FW: Y/18/26/PL

Subject: Y/18/26/PL

However, there are still some irregularities regarding the site boundary line shown on a number of the submitted layouts. The proposed layouts appear to encroach into the rear gardens of the neighbouring properties. Please could these be rectified and amended plans provided for the following drawings:

Figure 2. Planting Plan of the proposed development (Drawing No. GLS_050_132_1500) (GreenLandscape, 2026)

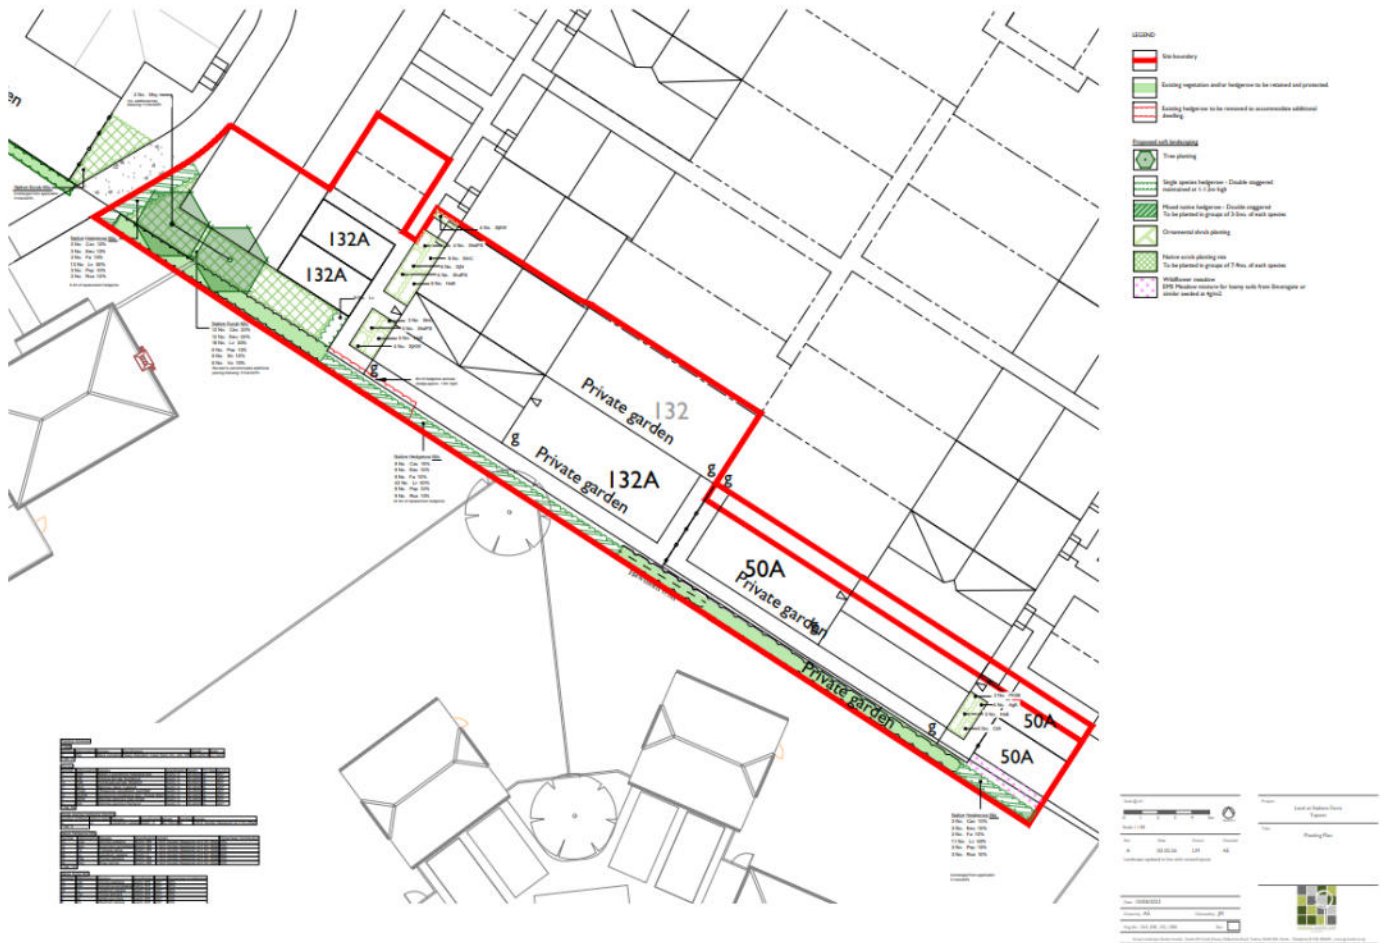
- **General Arrangement Drawing:** GLS_050_132_1500 Rev C
- **3 no. Drainage Plans** submitted as part of the application
